CONSERVATION OFFICER PLANNING CONSULTATION

Reference Number: H17-0503-26

Proposal: Demolition of existing building and re-location of existing access - Part Retrospective

Location: Rear of The Mermaid Inn, 2 Gosberton Road, Surfleet, PE11 4AB

F	EXISTING BLOCK PLAN ADDED - PLANNING	JUN 2026
E	PLANNING AMENDMENTS	MAY 2026
P	SCHEME REDESIGN	MAY 2026
C	SCHEME REDESIGN	MAY 2026
B	CLIENT AMENDMENTS	MAY 2026
A	CLIENT AMENDMENTS	MAY 2026
ref.	revision	date

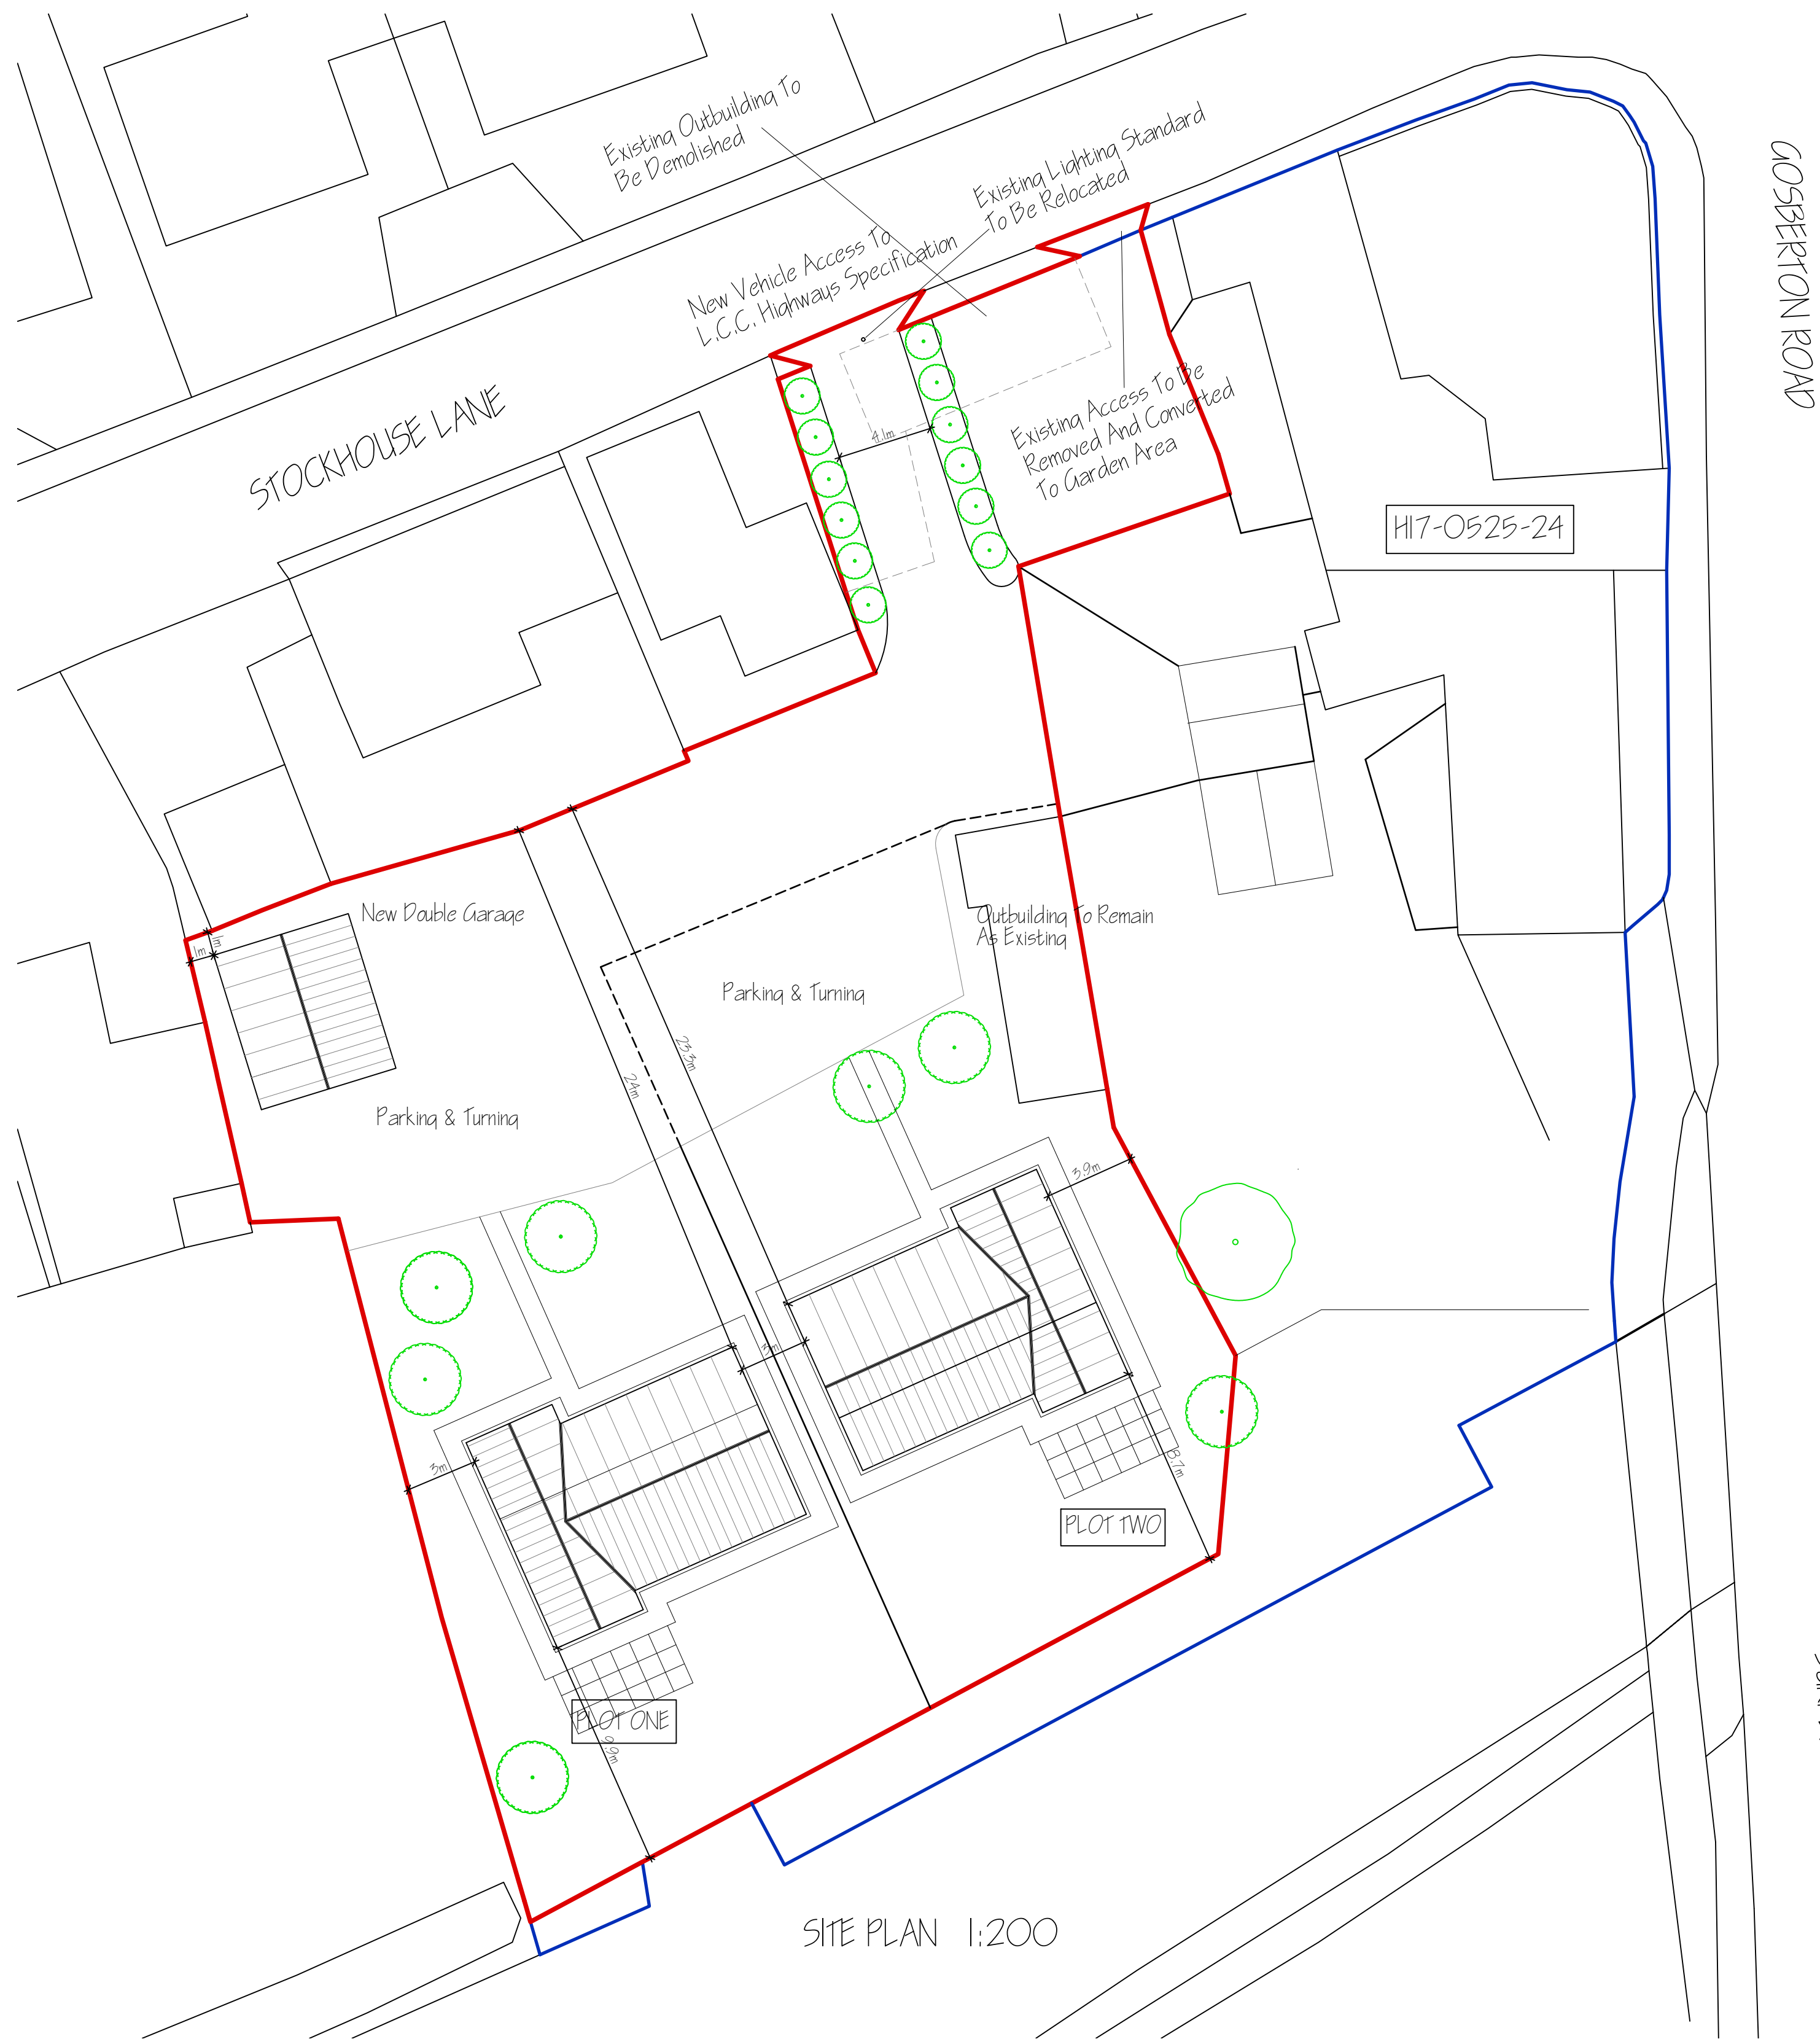
Regarding the housing development to the south side of the site, consisting of x2 large independent dwellinghouses; I do not object to the principle of the proposal, nor to the basics of the design. However, I do have concerns about the materials proposed to be used throughout the development. The previous scheme consented on this site proposed natural timber boarding, as well as white painted timber windows and doors, which I believe led to a softer appearance that sat better within its setting.

I think perhaps we have lost a little sight of the fact that this is a significant development directly in the curtilage of a listed building, and as such, respect must be paid to the quality of materials to be proposed throughout. I would therefore request that the application be amended to remove the cedar boarding to be replaced with genuine timber (shiplap boarding may be locally appropriate).

In addition, I also believe that the structure would be better served by white, timber windows similar to those approved under the previous scheme, however, rather than confirming right now that this is a necessity, I think a mock up of this would be beneficial to see before a final consultation.
